## Additional Information Requested for Validation

Application for the conversion and change of use of an existing commercial holiday let (restricted C3) into a residential dwellinghouses (C3) and division of residential curtilage

at Moor Farm, Black Lane, Doddington

**1.2** The letter received from NKDC confirmed the application reference to be 22/1741/FUL

Drawing Title
 Proposed Elevations and Sections
 PLANNING

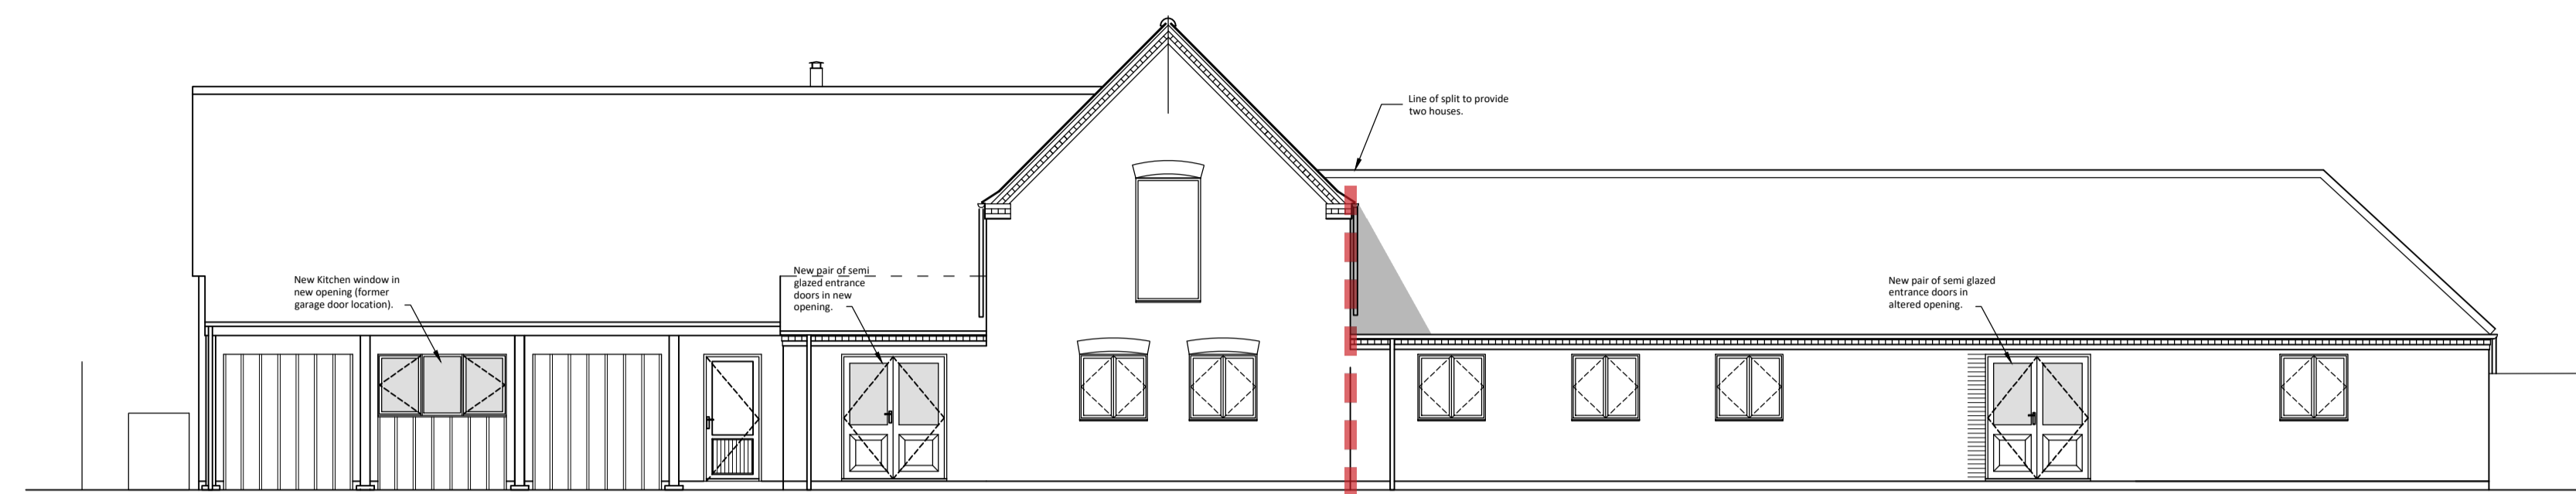
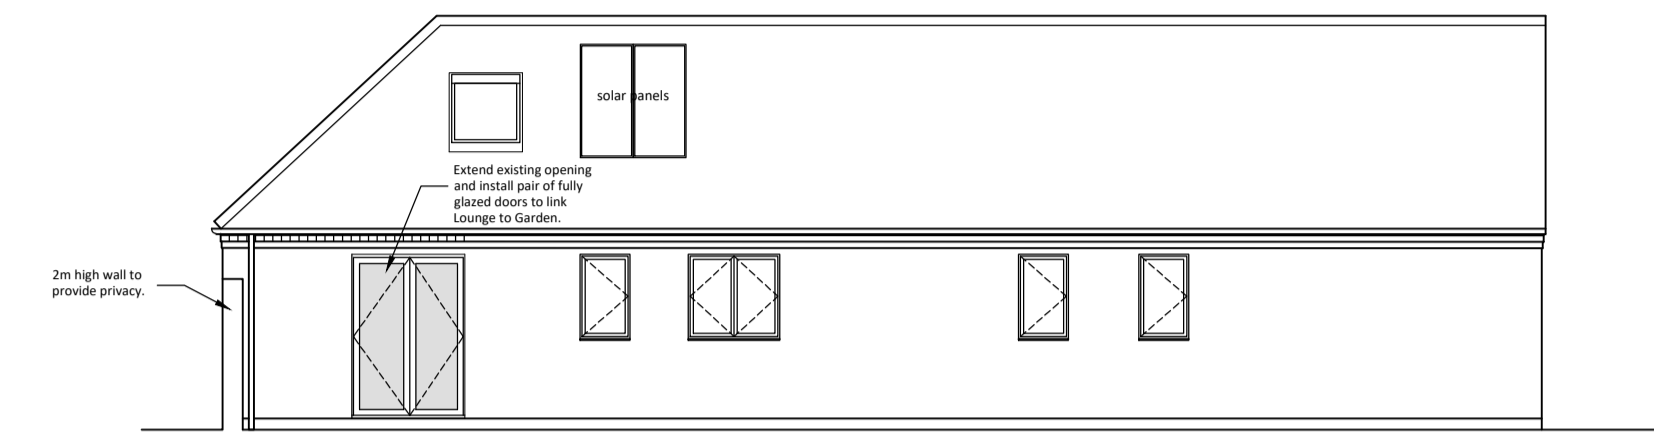
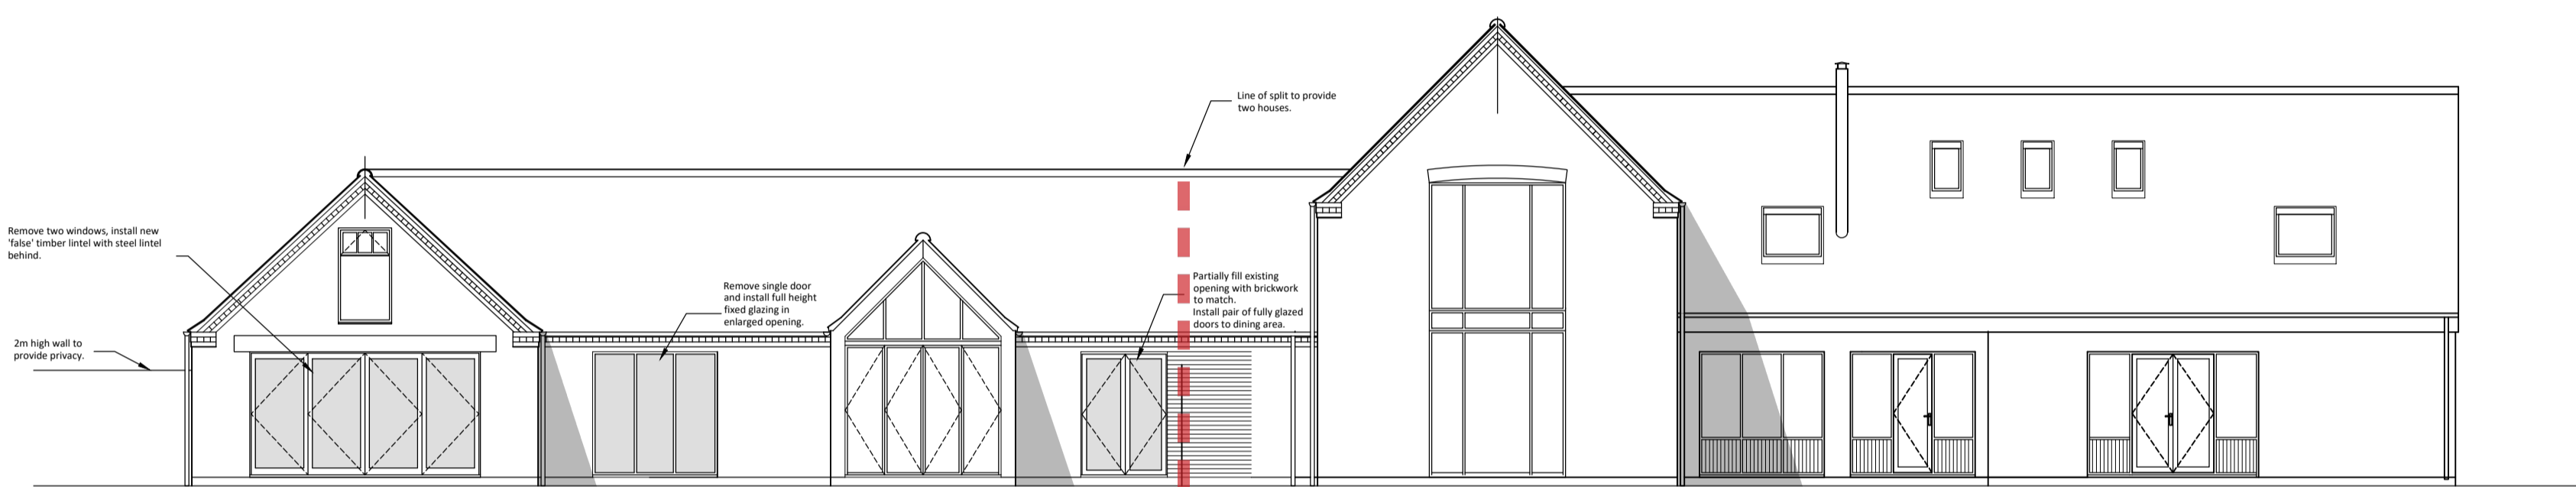
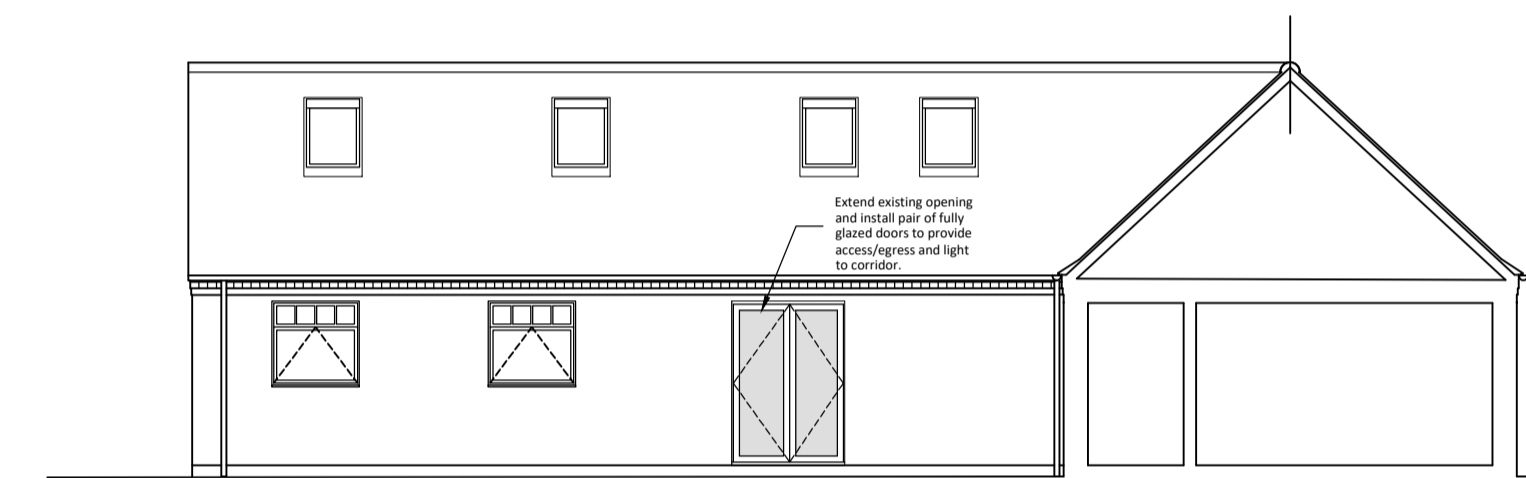
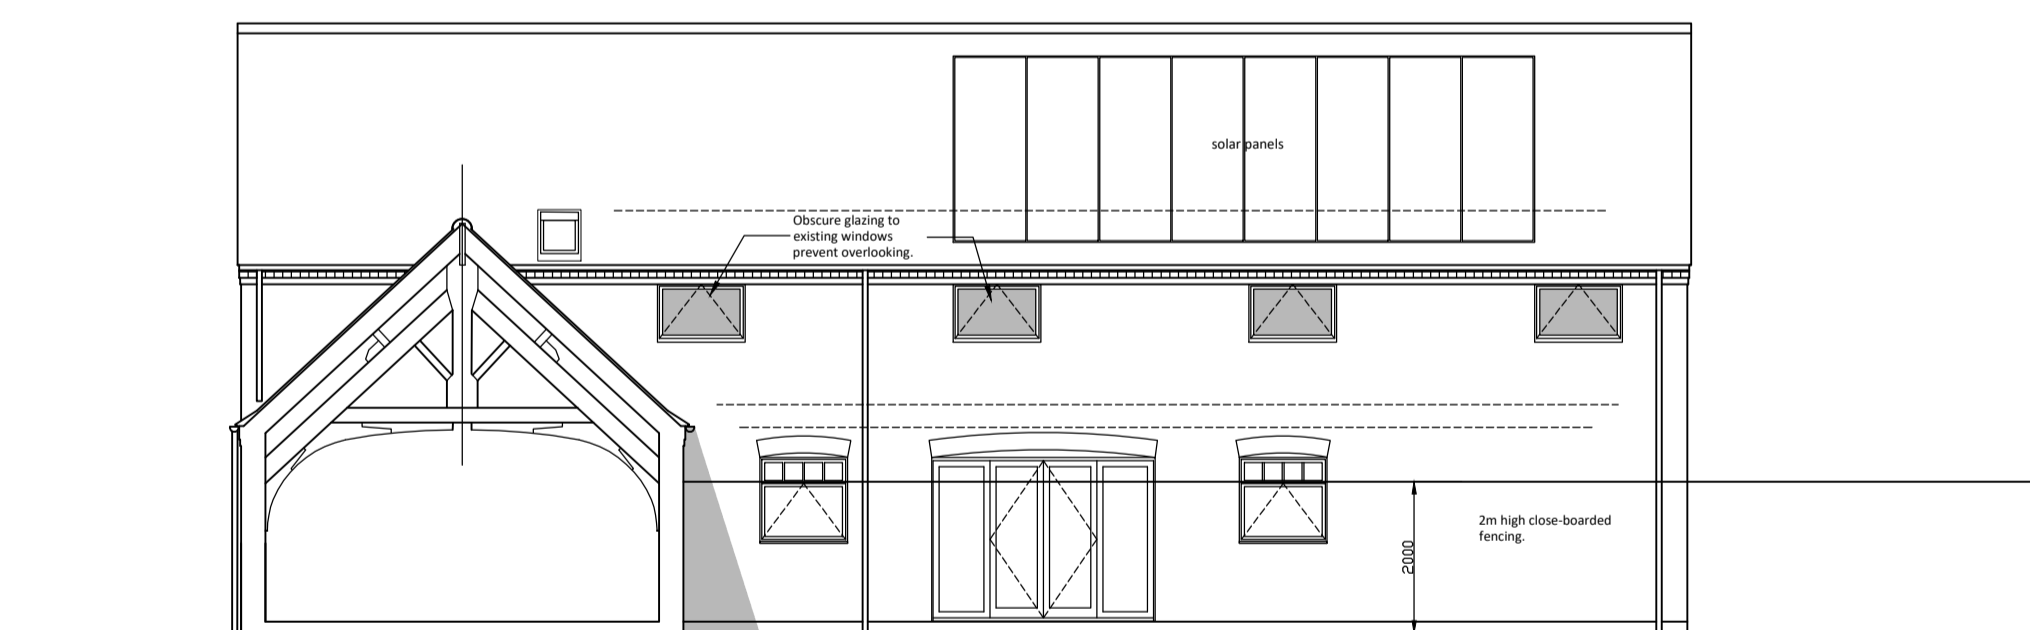
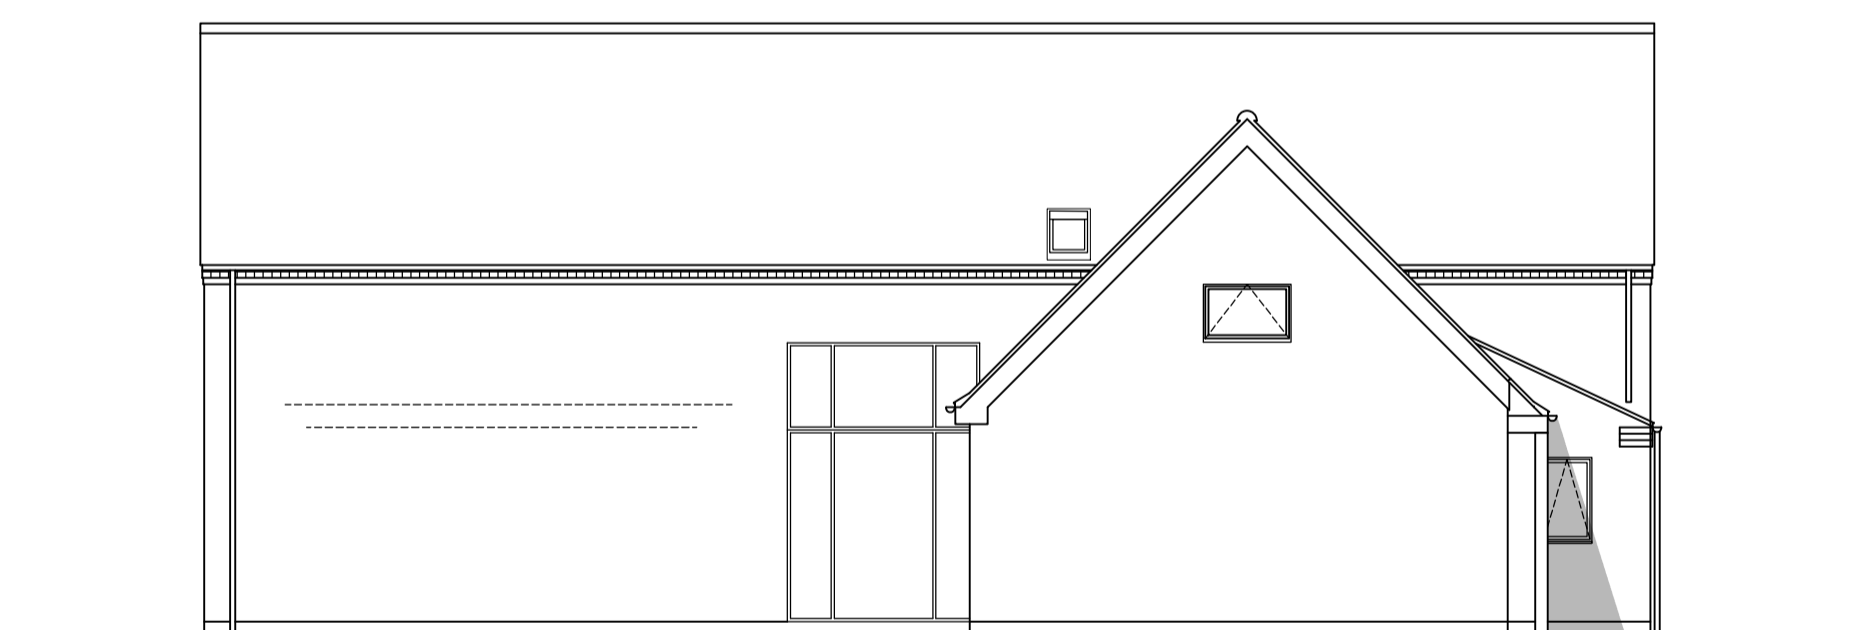
- **Question 1:** Request to complete a CIL form;
- **Question 2:** Clarify the details of any installation of new doors and windows;
- **Question 3:** Amend the materials section of the application form;
- **Question 4:** Further details of boundary treatments.

### North West elevation:

- New wider entrance door for each property replacing existing narrow doors.
- New kitchen window in garage door location for plot 2 overlooking paddock.

### North East elevation:

- Slightly widen existing door opening to allow for pair of fully glazed doors to give access from lounge to patio. In plot 2 .

### South East elevation:

- Reduce size of glazed window with central opening door on plot 1 to facilitate division of property (see dashed line on elevation drawing).
- Replace door in elevation of plot 1 with triple glazed panel to allow in light lost by reducing glazing noted above.
- Insert new quadruple glazed panel with central opening doors into gable end of plot 1.

### South West elevation—Plot 1:

- Replace window in proposed lounge with pair of fully glazed doors to allow access to patio.

**1.6** All new doors and windows will be set in reveal to retain the agrarian appearance and character of the building as per existing fenestration.

- Pressure treated softwood with light Oak stained finished;
- Traditional bead profile to match existing windows;

- 36mm triple glazed units to comply with Building Regulation Approved Document L;
- All full height glazing to be safety glass.
